**Section 75W Modification Request:
DEXUS Estate Industrial Park
Greystanes Southern Employment Lands,
Holroyd Local Government Area
08_0259 MOD 2**

Director-General's
Environmental Assessment Report
Section 75W of the
Environmental Planning and Assessment Act 1979

March 2012

scale 1:2500 @ A1
date 09.02.2012 1:5000 @ A3
drawing no. DX_G_MP08.01 rev H

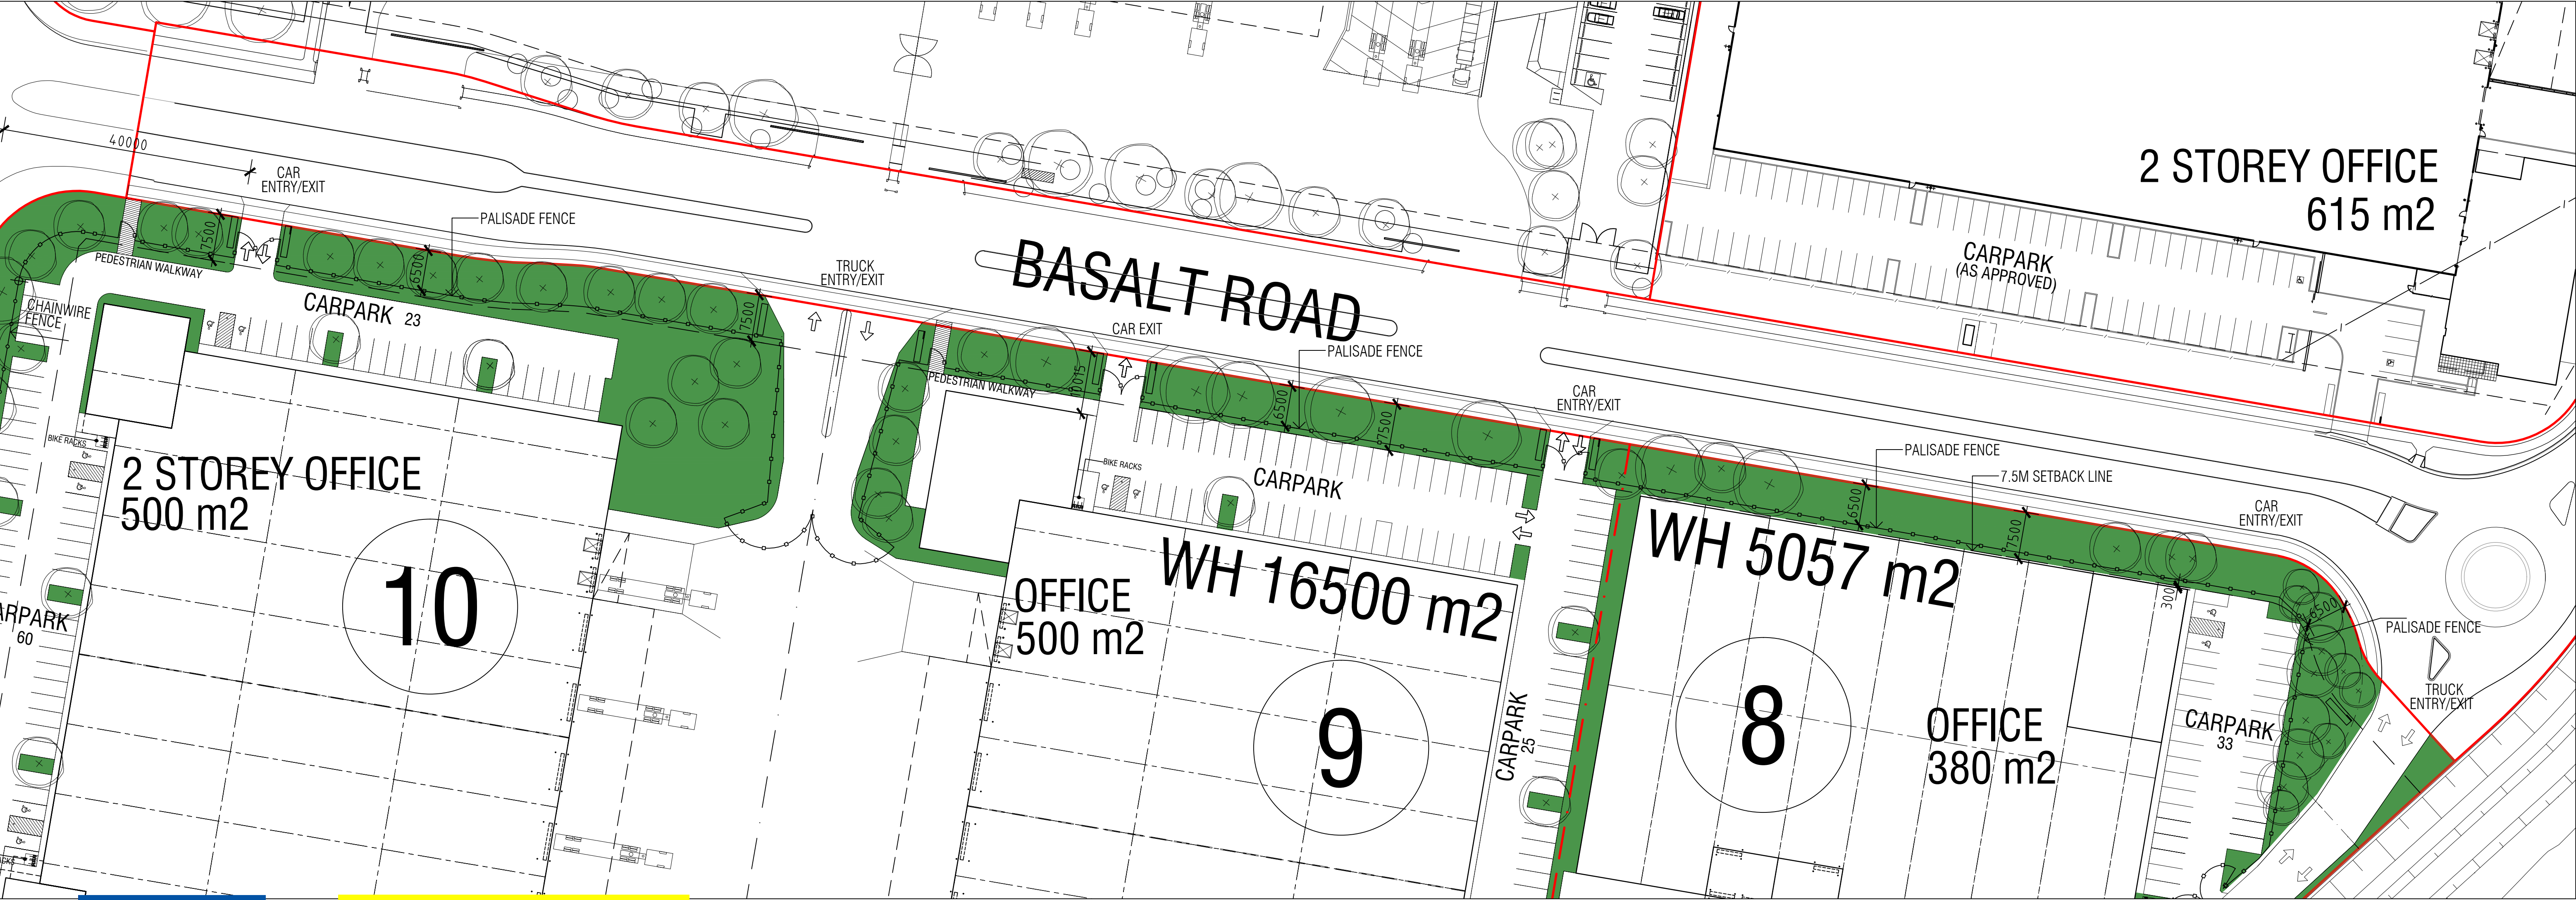
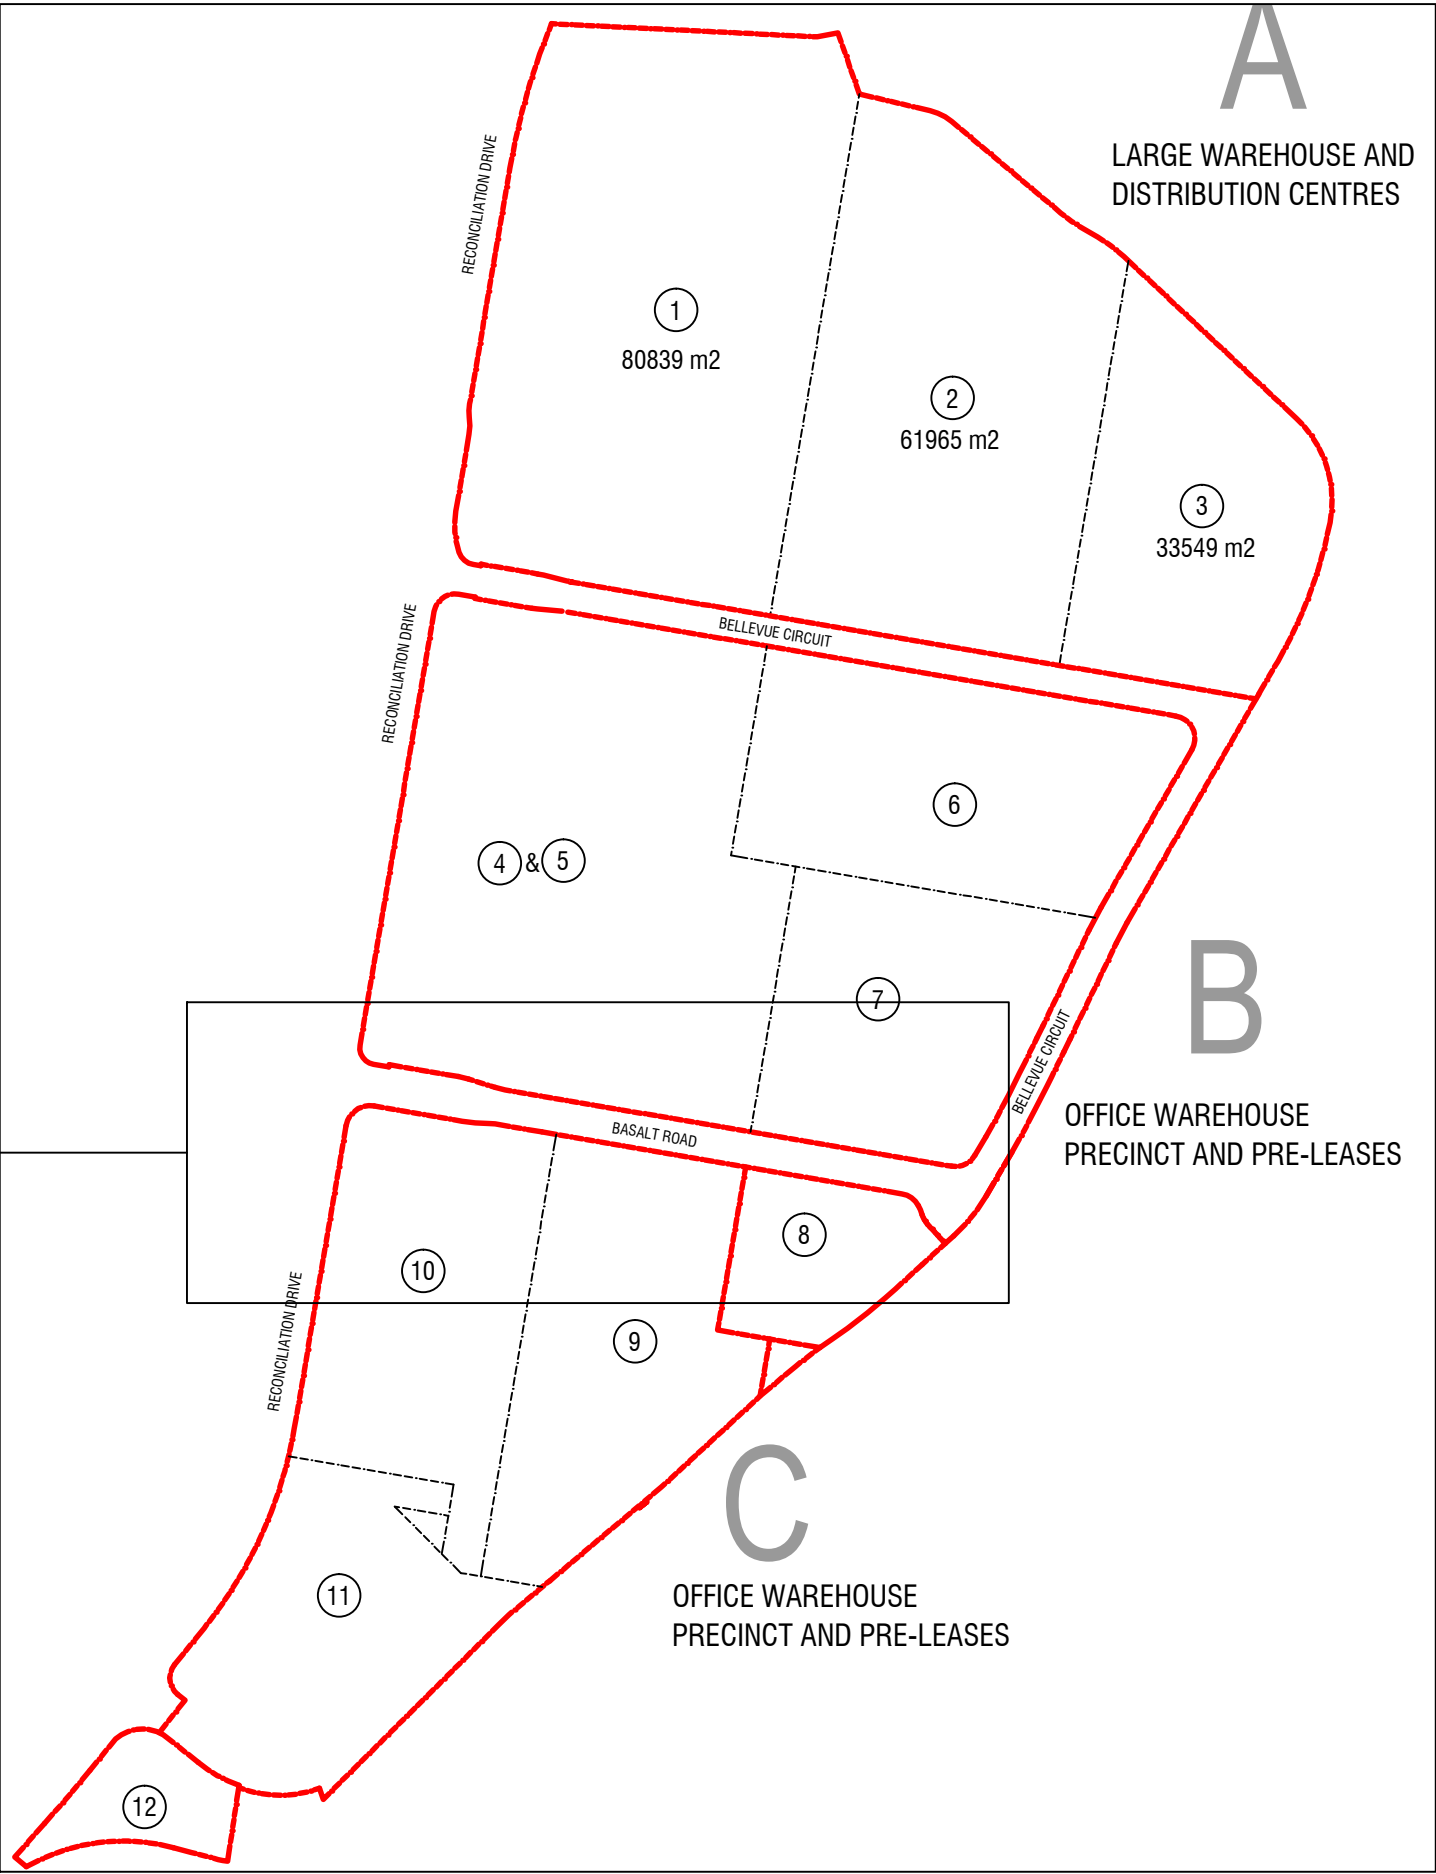
- Condition 12 of schedule 2 - Café Not Approved
The café shown on plans provided for MOD 2 including amended Overall Site Masterplan DX_G_MP08.01 Rev H (09.02.2012) and Precinct C Masterplan DX_G_MP08.05 Rev H is not approved.

scale 1:1000 @ A1
1:2000 @ A3
date 09.02.2012
drawing no. DX_G_MP08.05 rev H

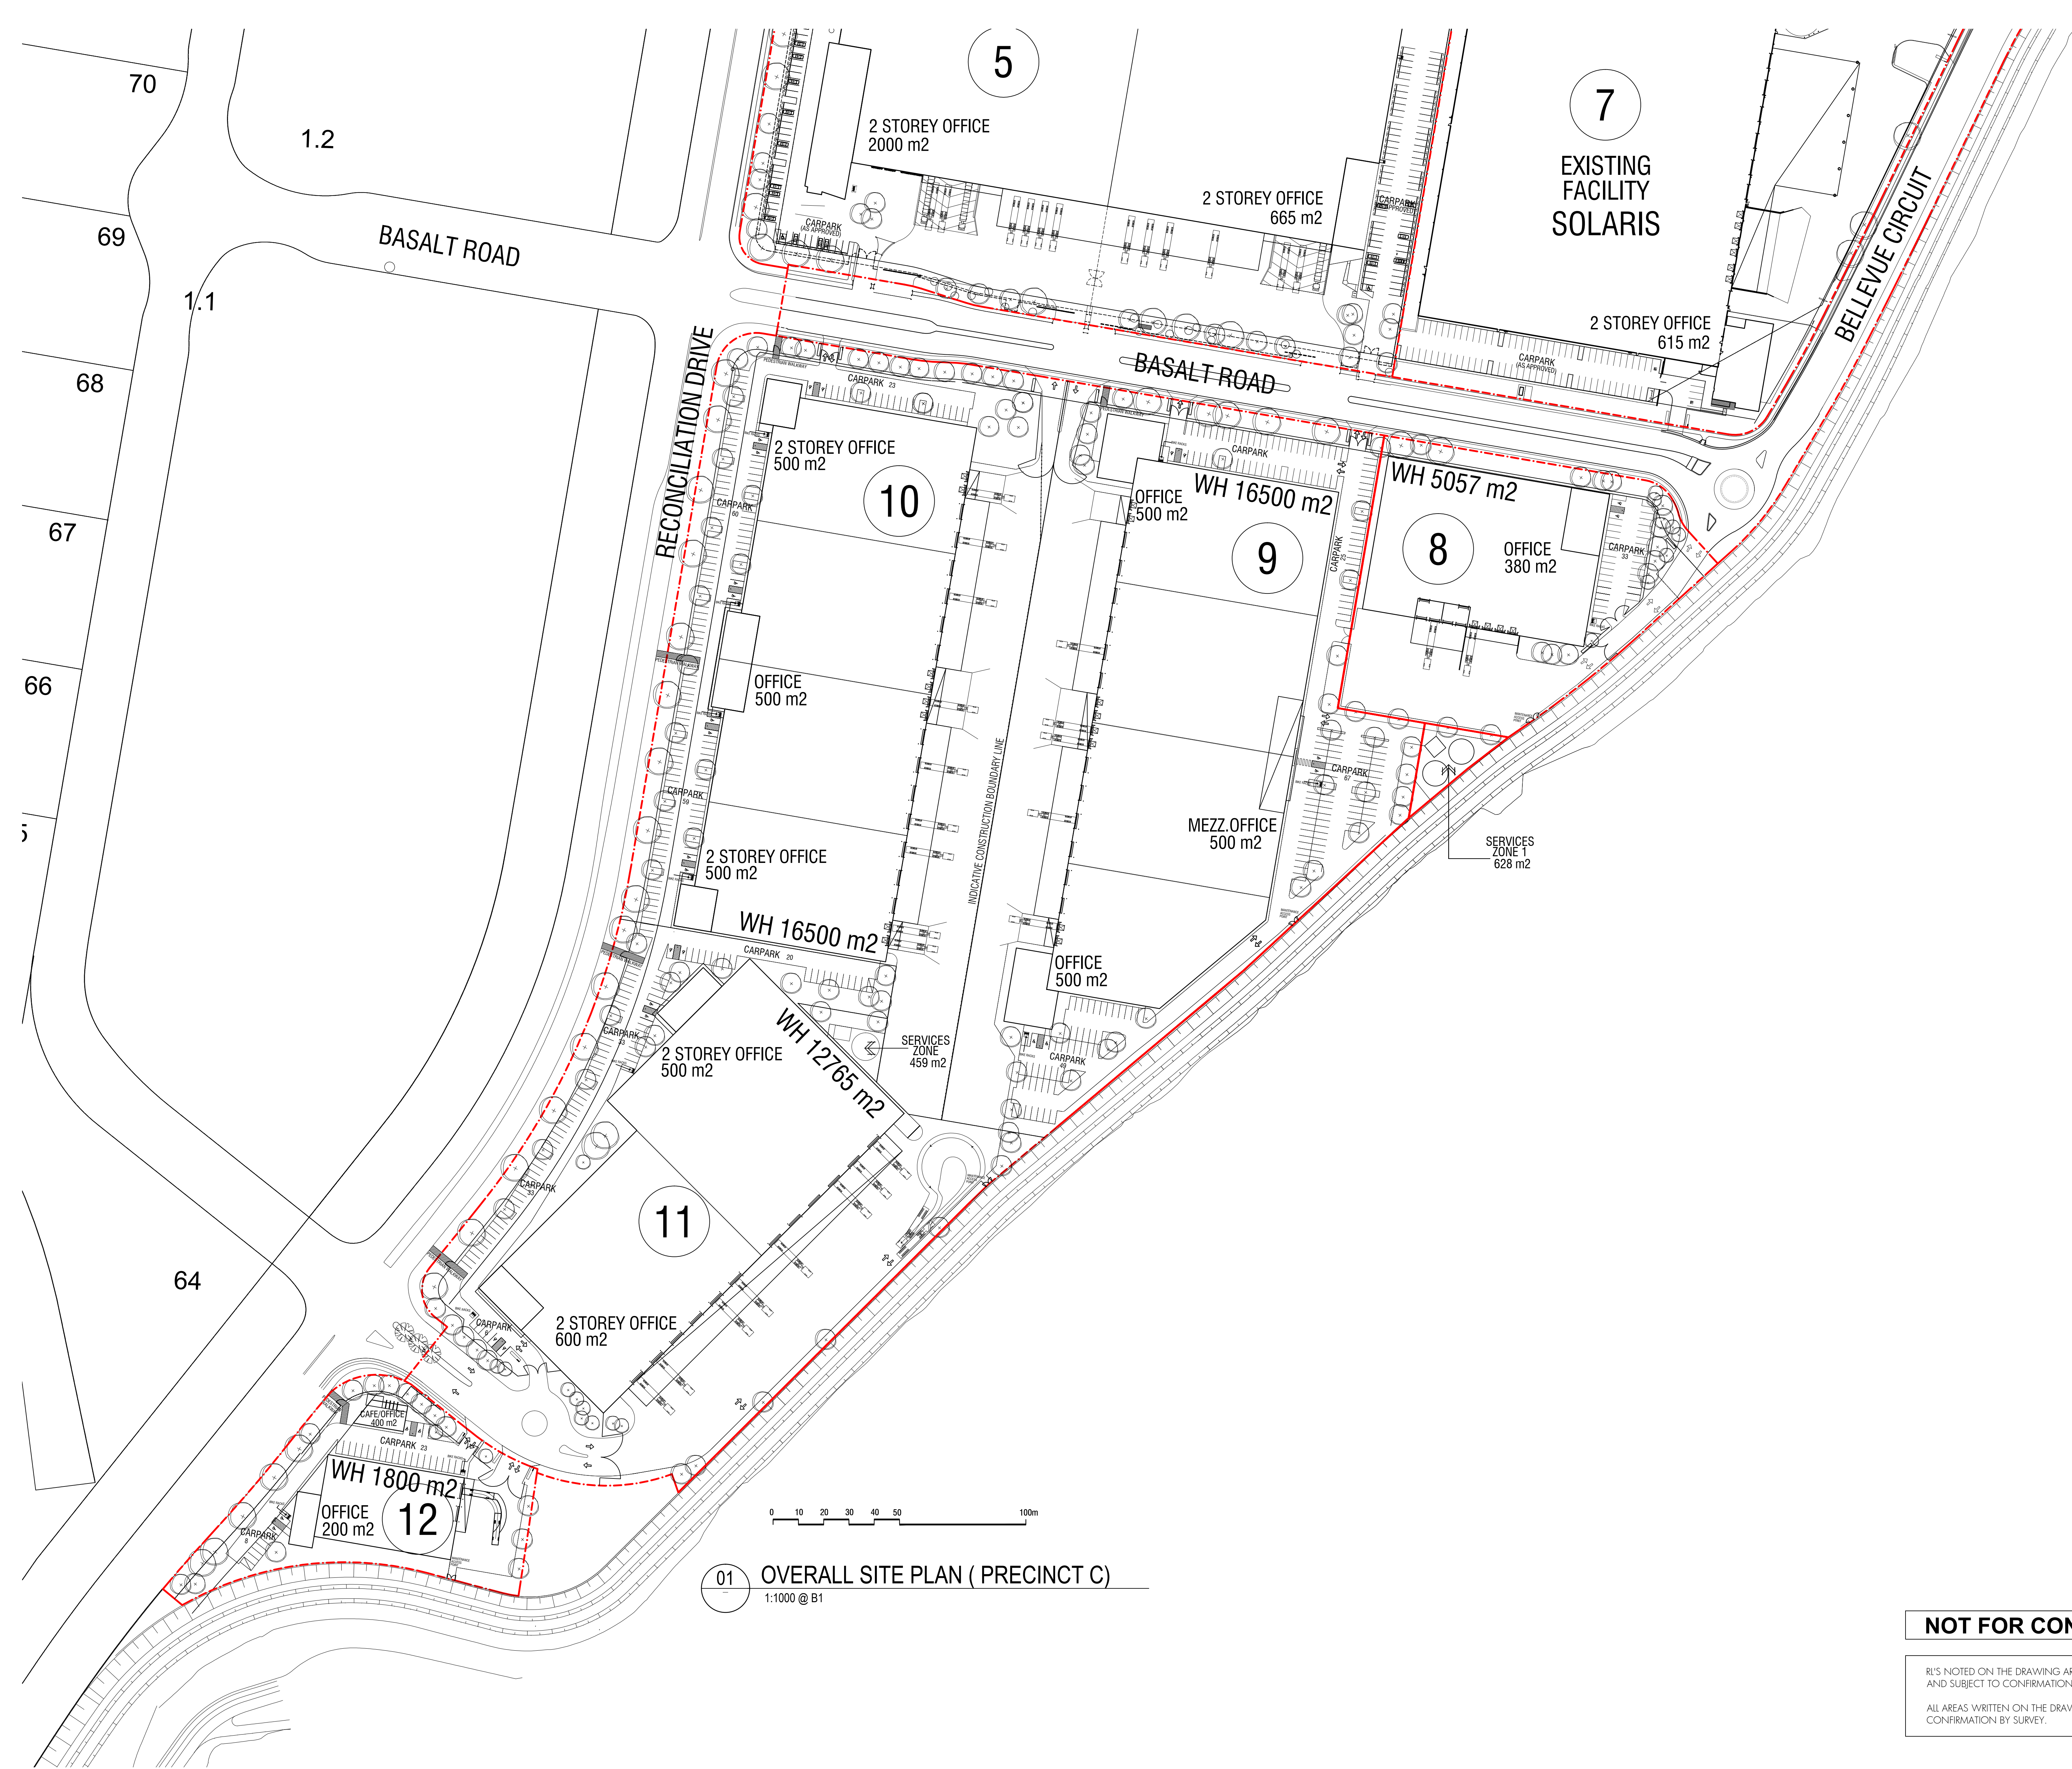
Issue	Potential Impacts/Consideration	Recommendation
<i>Cafe</i>	<ul style="list-style-type: none"> The department raised concerns regarding the location of the café within the estate. If the location of the café is too far for estate patrons to comfortably walk to they are most likely to drive to visit the café. Concern was raised about the small number of parking spaces provided for the café (7.5 spaces) and that during busy times of the day café patrons may use parking spaces provided for the adjacent warehouse (warehouse 12). DEXUS acknowledged that by using the retail parking requirements of the RMS Guide to Traffic 	<ul style="list-style-type: none"> It is recommended that the café not be approved as part of this application, allowing for further planning and assessment to be undertaken to determine an appropriate location within the estate for a café and provision

Generating Development the café would require an additional 9 spaces. The proposed solution was to decrease the GFA of the café in order to reduce the parking requirement and enable compliance with the RMS Guideline. The department does not support this solution.	of adequate parking. 'Café not approved' annotations will be made to the approved plans. DEXUS raised no objections to this.
Traffic Management	<ul style="list-style-type: none"> It is considered that council's concerns in relation to the safety of access arrangements for vehicles entering and exiting lots have been addressed by the proponent through revised plans and commitments and by existing conditions. Council had also initially required that the intersection of Basalt Road with Reconciliation Drive be left in/left out, however the council has since resolved to keep Reconciliation Drive closed to through traffic at its southern end until traffic lights have been installed, thereby removing the traffic safety concerns at the intersection. Council requested that a condition be provided restricting vehicles entering lots be no longer than the design vehicles for these lots. The department concurs with this request. 	<ul style="list-style-type: none"> It is recommended that access to lots be restricted to vehicles no larger than the design vehicles for these lots.
